PLANNING CONSULTATION RESPONSE

Application No	2026/0568
Proposal	Erection of single storey front extension at ground floor level, and single storey rear and side extensions to lower ground floor level of dwelling
Address	53 Old Mill Lane, Thurgoland, Sheffield, S35 7EG
Date of Consultation Reply	11 th August 2026
Consultee	Highways DC

DRAWING TITLE	Proposed GA Plans
---------------	----------------------

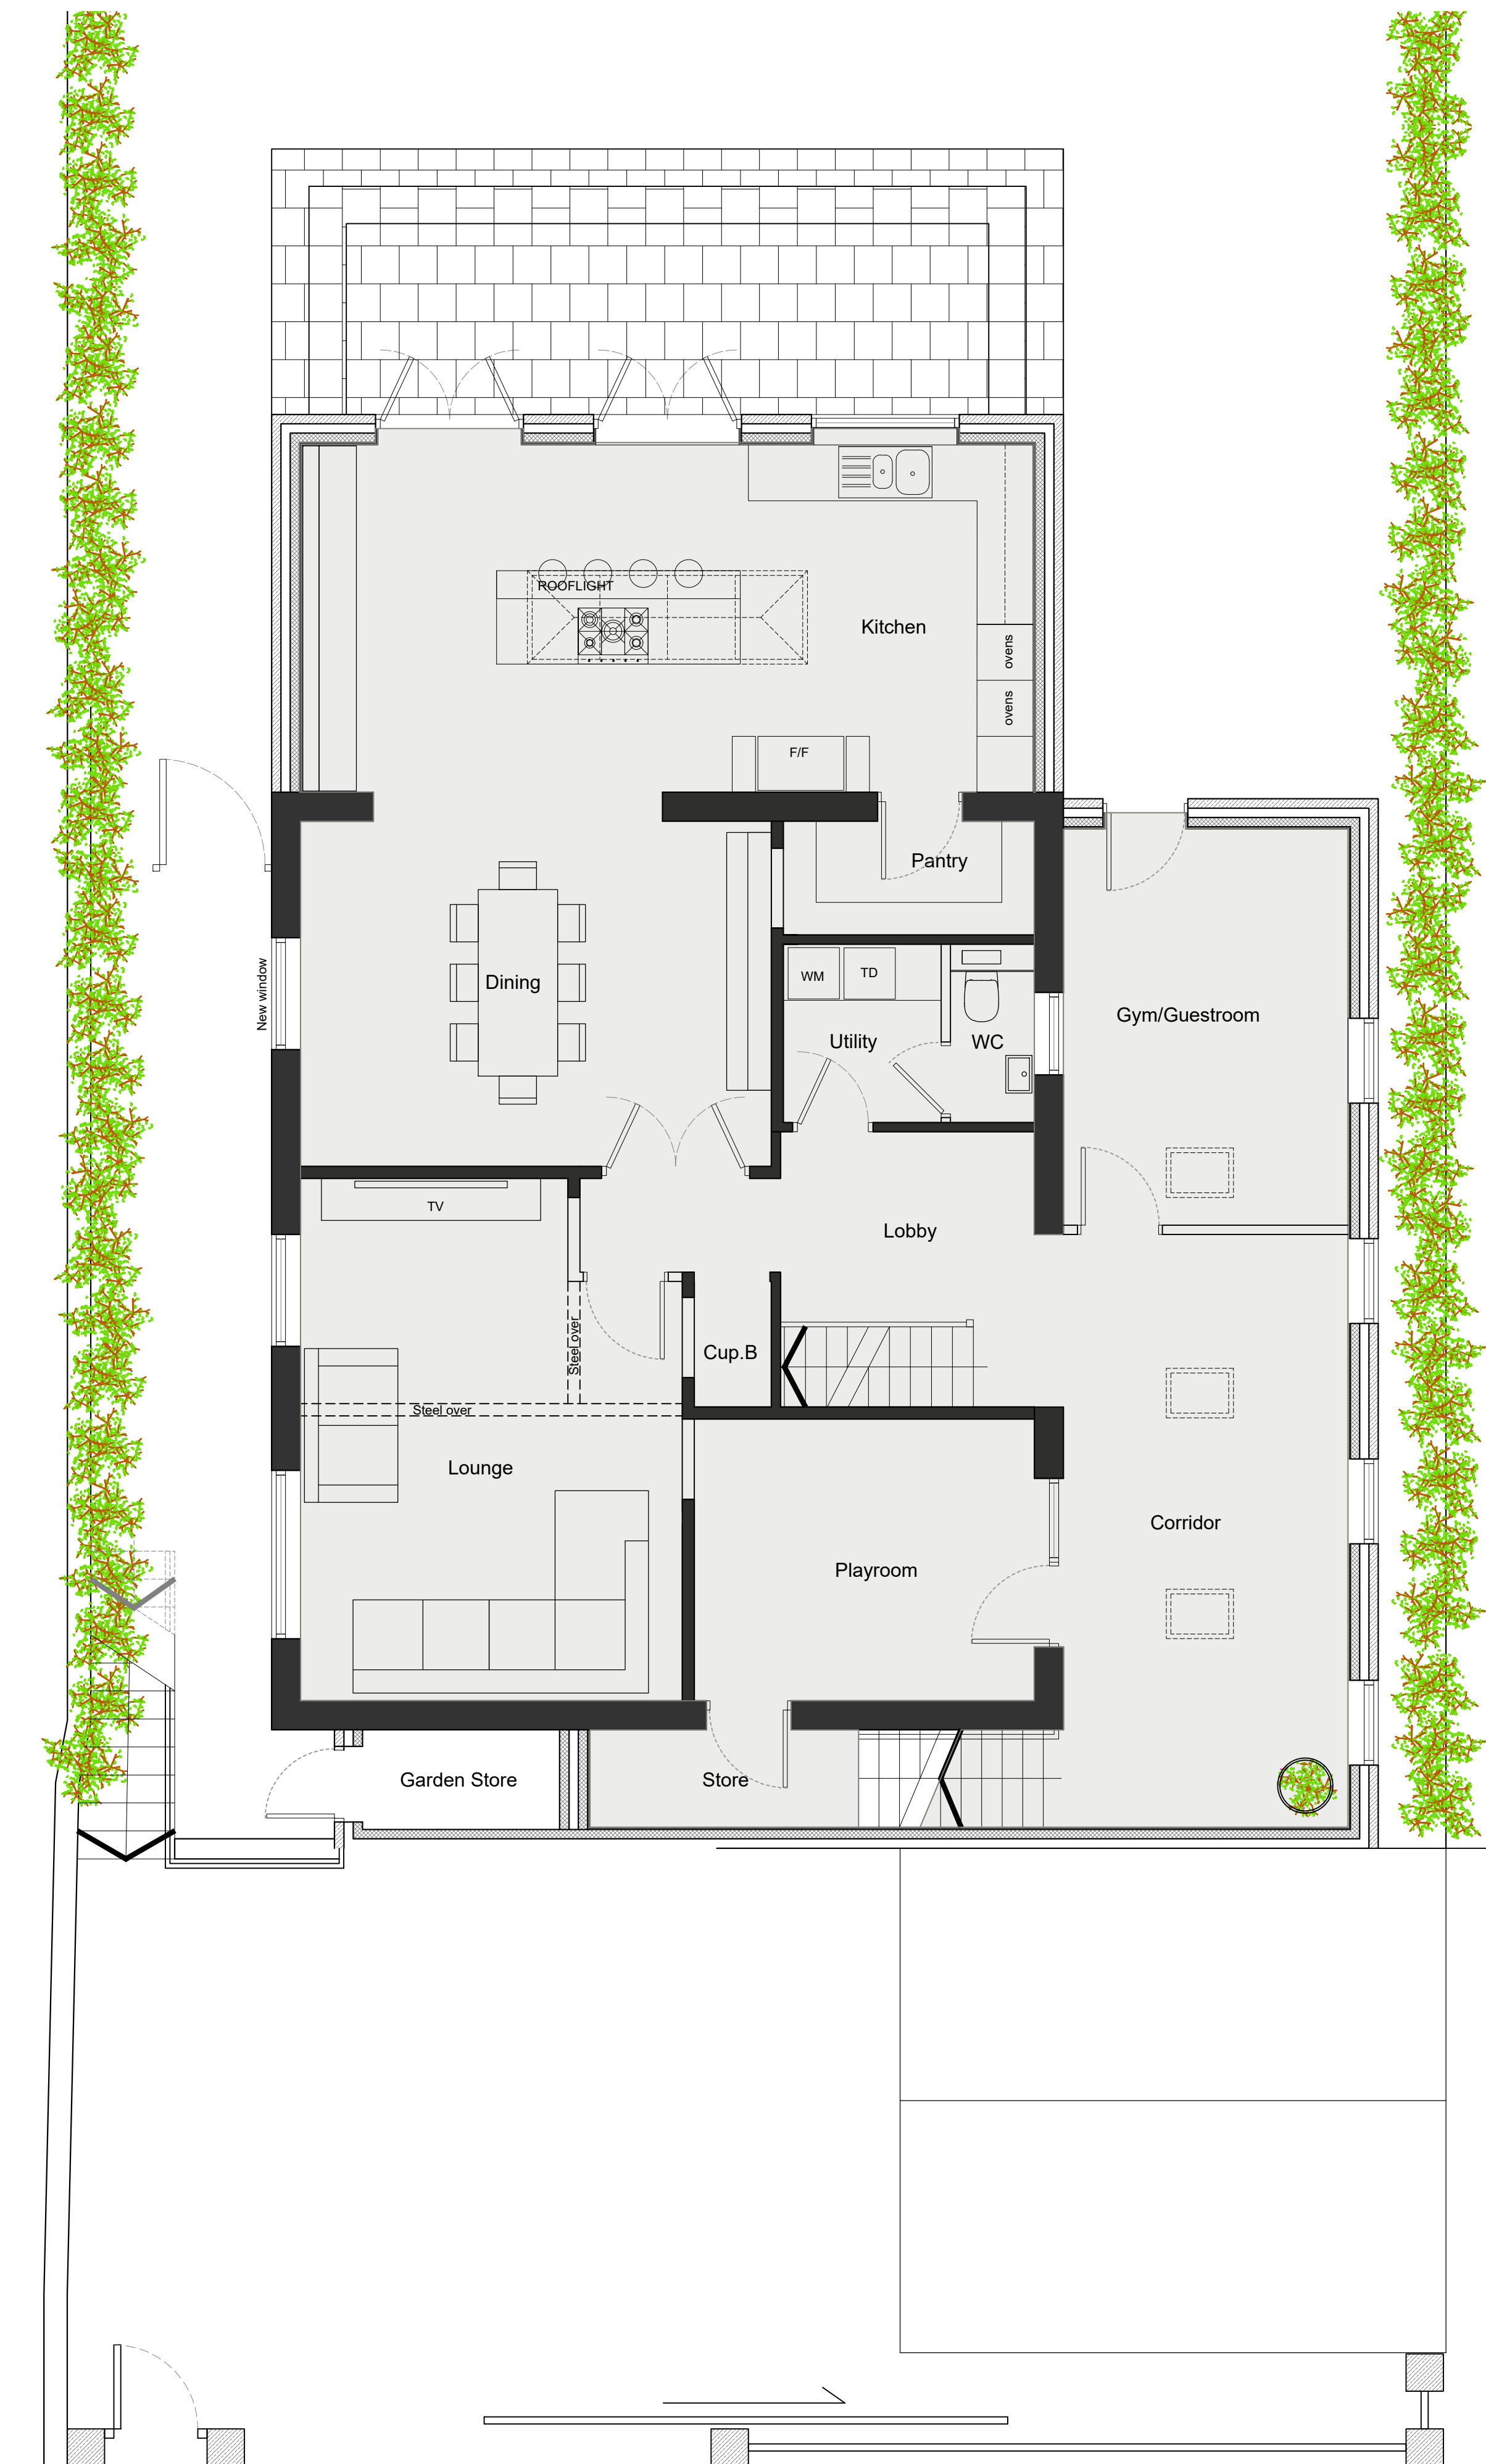
The proposed front extension results in a small reduction to the size of the frontage parking area, however, it can be seen from the site layout plan that the site would retain sufficient provision for the parking of two vehicles as per the Council's Parking SPD. Although the garage has an internal length of 5.5m which is less than the generally required 6m, given the overall size of the garage with a width ranging from 3.8m to 5.1m (well above the required 3.0m), the garage is considered to be of sufficient size to be counted as one parking space.

The proposals include the erection of a boundary wall/fence along the site frontage which incorporates a sliding gate; the 5.0m width of the opening is sufficient to allow for the required 2m x 2m pedestrian intervisibility splays.

Prior to the development being brought into use, all areas to be used by vehicles shall be laid out in accordance with the approved plan and must be properly consolidated and hard surfaced and drained into the site and subsequently maintained in good working order at all times thereafter for the lifetime of the development.

Prior to the development being brought into use, the vehicular access shall provide pedestrian visibility splays of 2m x 2m to the edge of the public highway. Nothing shall be erected, retained, planted and/or allowed to grow at or above a height of 0.6m to the rear of the public highway which would obstruct the visibility splays. The visibility splays shall be maintained free of obstruction at all times thereafter for the lifetime of the development.

Any gates shall be set back from the edge of the public highway and designed to only open inwards and be permanently retained as such. When in an open position, the pedestrian visibility splays of 2m x 2m shall remain safeguarded such that there is no obstruction to visibility at a height exceeding 600mm above the nearside channel level of the adjacent highway.
